**DELEGATED DECISION TO DETERMINE APPLICATIONS FOR LISTED
BUILDING CONSENT**

Reference No: 2018/65/92987/W

Site Address: The Barn, 9, Moor Cottage Close, Netherton,
Huddersfield, HD4 7LF

Description: Listed Building Consent for formation of new window
openings

Client:-	Graham Hunt
Address 1	9, The Barn
Address 2	Moor Cottage Close
Address 3	Netherton
Town	Holmfirth
Post Code	HD4 7LE
Tel No.	07912781263
Order Ref No.	CH1068
DWG Title	Proposed Front view of 9 MoorCottage Close
DWG No.	CH1068 - 04
Scale 1:50	
REV 3

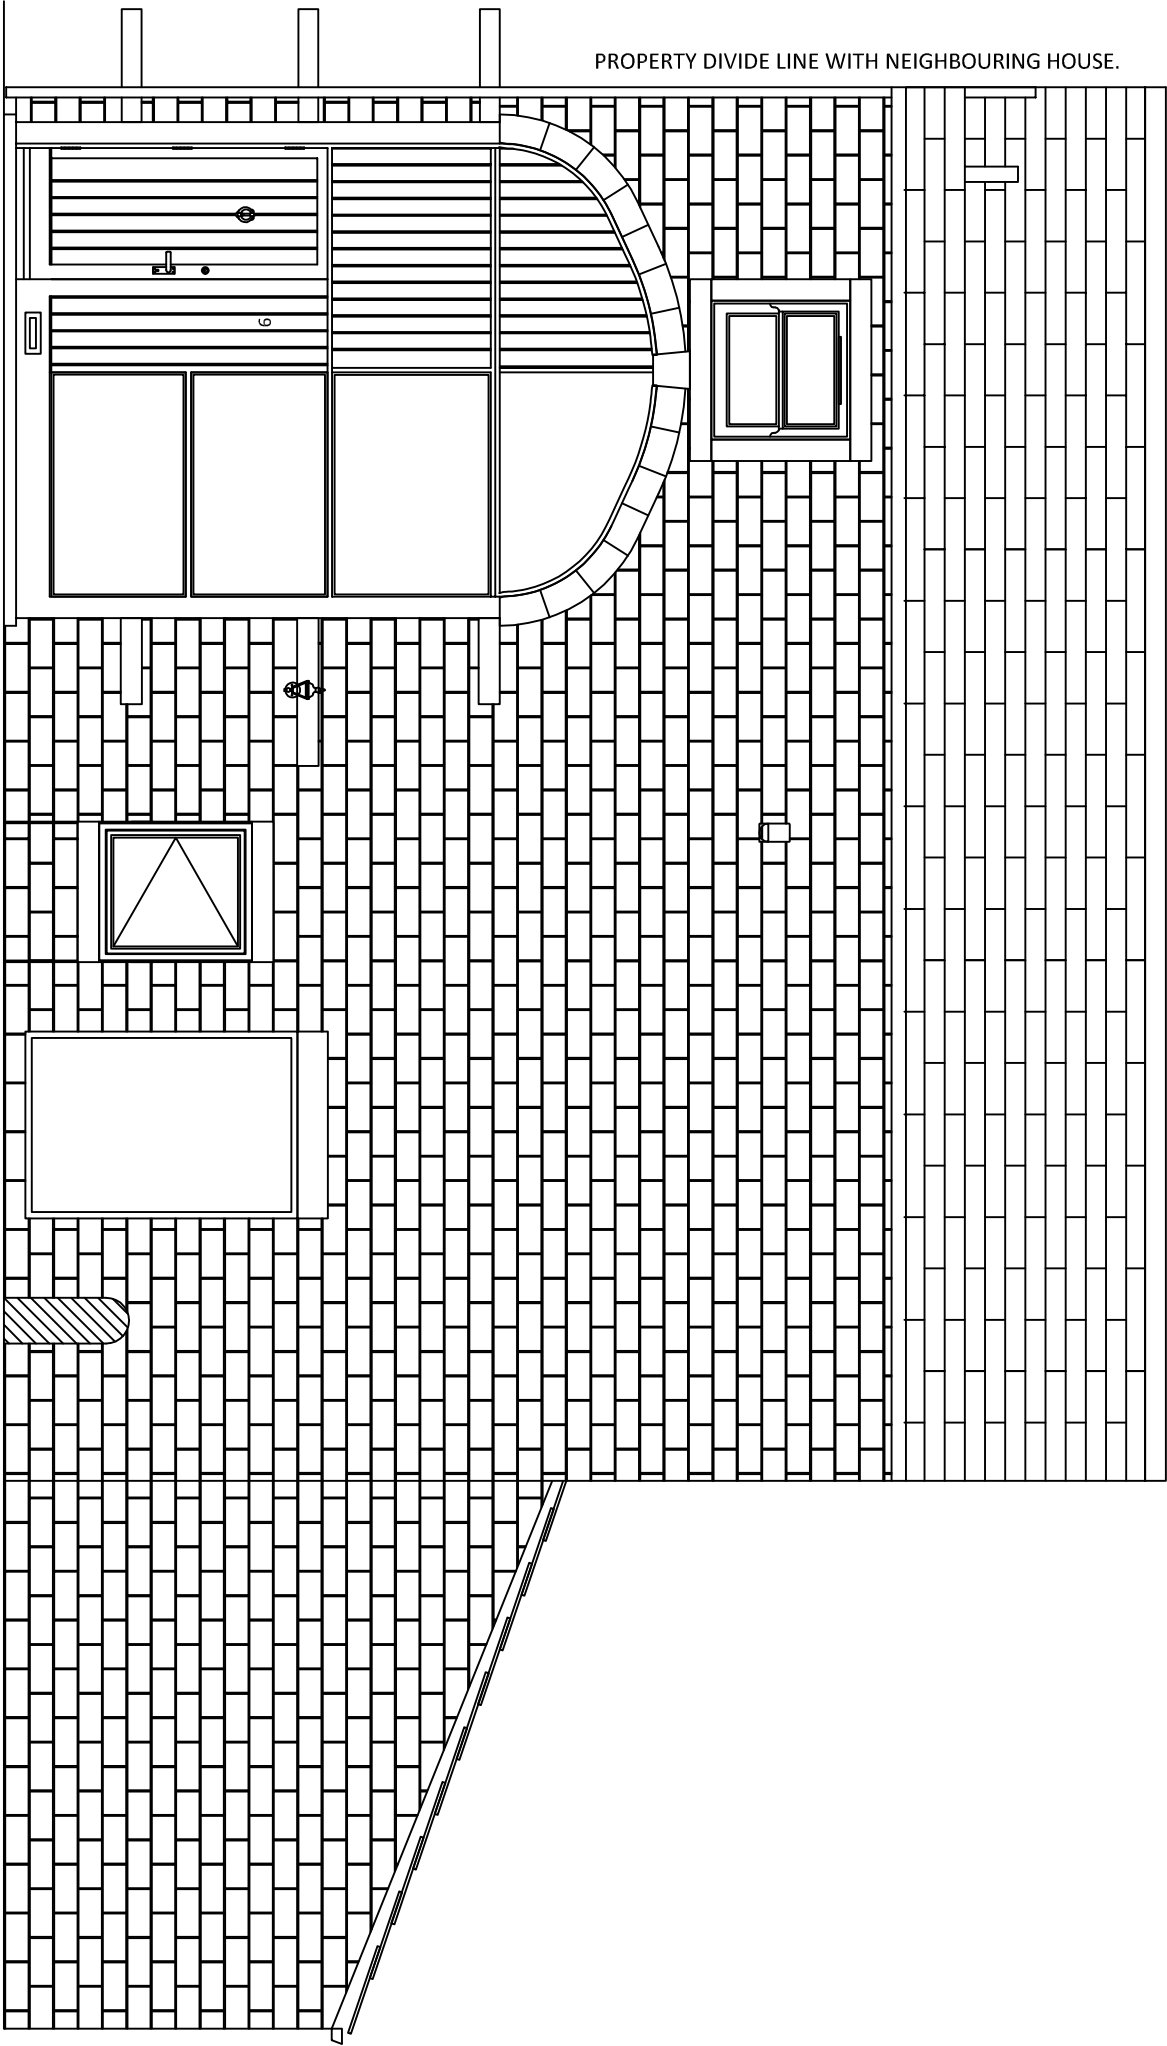
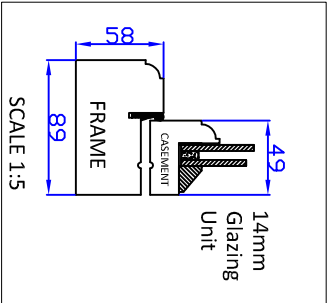
Insertion of a new window within an existing blocked door opening to the front – the initial proposal sort to raise the lintel height to match the adjacent opening. The difference in lintel heights has been retained to preserve evidence of how the building has evolved over time.

Client:-	Graham Hunt
Address 1	9, The Barn
Address 2	Moor Cottage Close
Address 3	Netherton
Town	Holmfirth
Post Code	HD4 7LE
Tel No.	07912781263
Order Ref No.	CH1068
DWG Title	Proposed Rear View of 9 MoorCottage Close
DWG No.	CH1068 - 05
Scale 1:50	REV 4

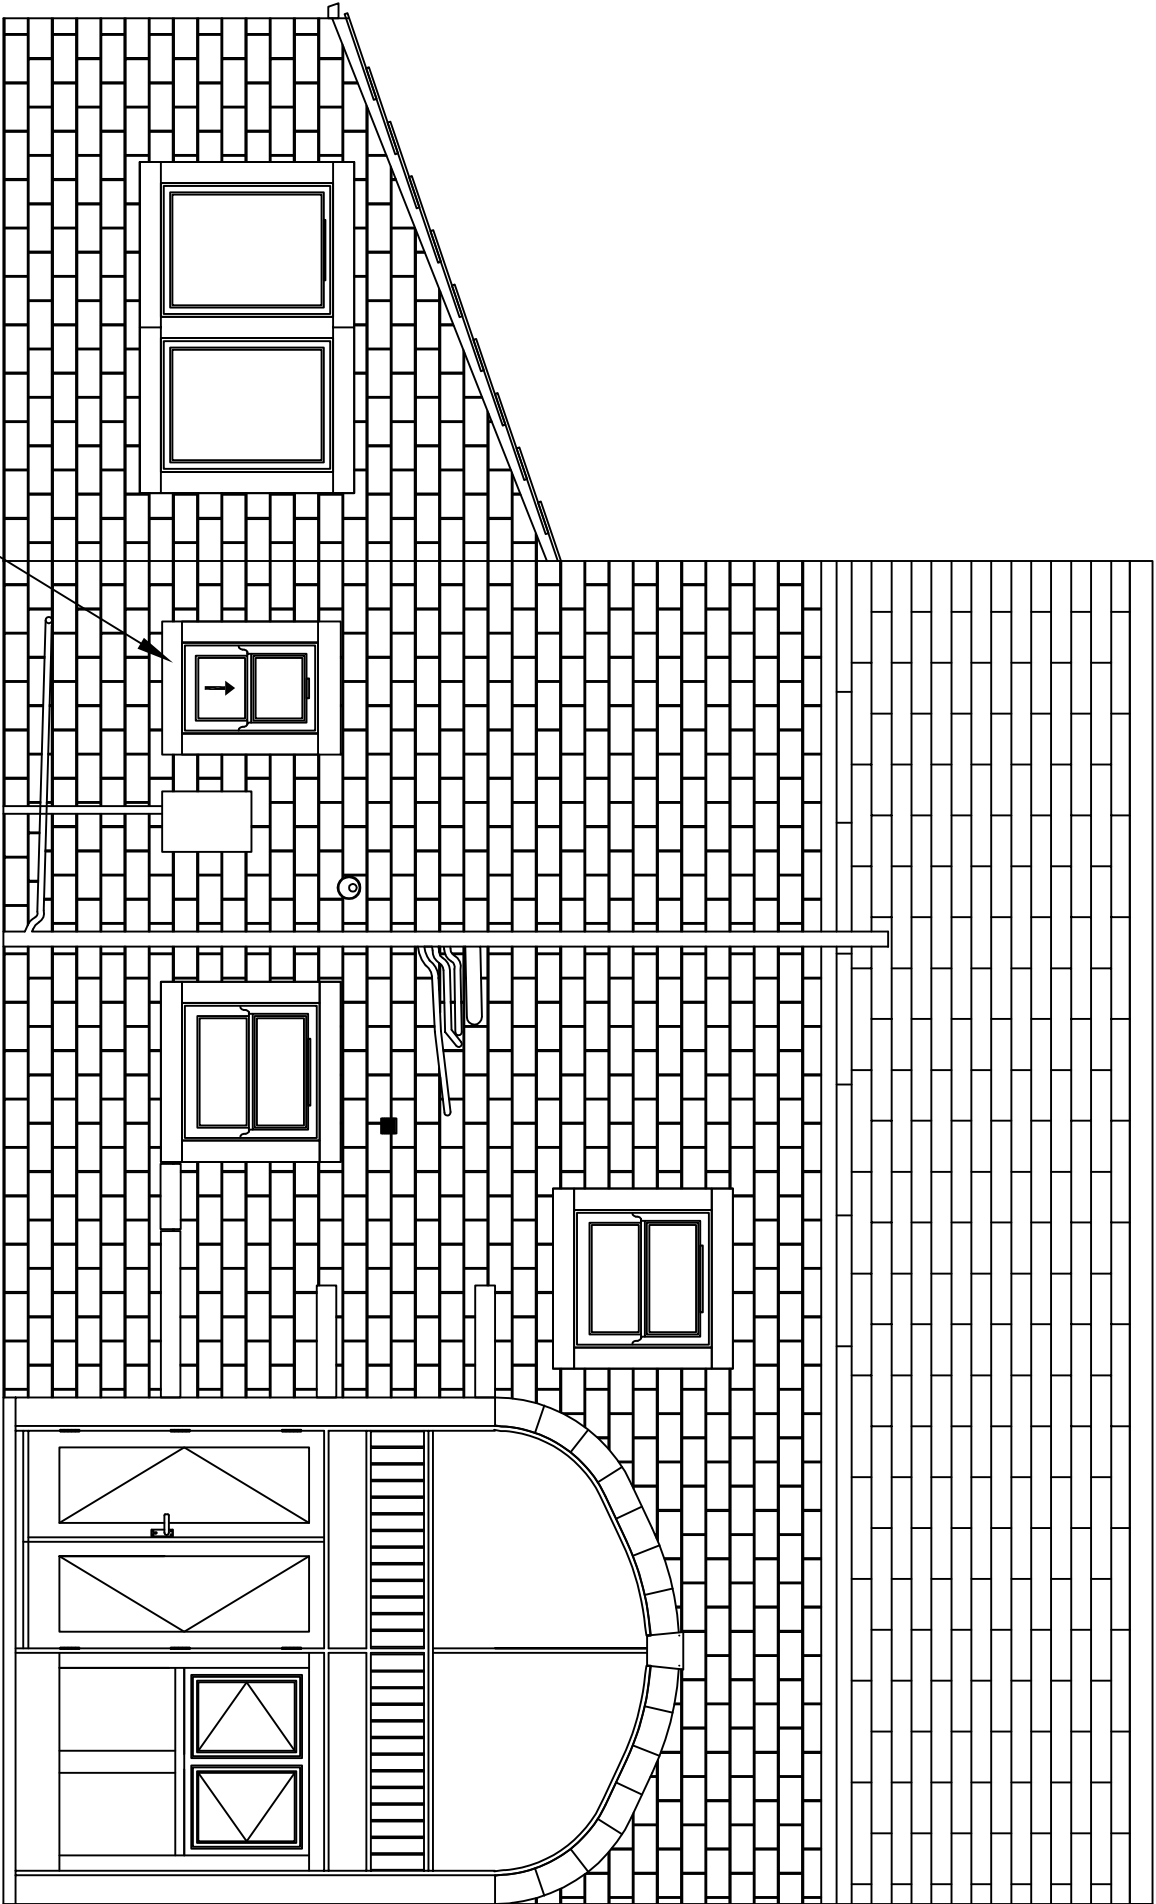
Formation of one new window opening to the existing cloakroom wc – the initial proposal was for a 'mock sash' top hung casement to match others at the property. This has been amended to a sliding sash window to accord with those previously approved.

Alteration of the timber panel infill to the barn opening to provide more light and ventilation– the initial proposal had an overly domestic character to it and has been amended to better relate to the existing doors within the barn door opening.
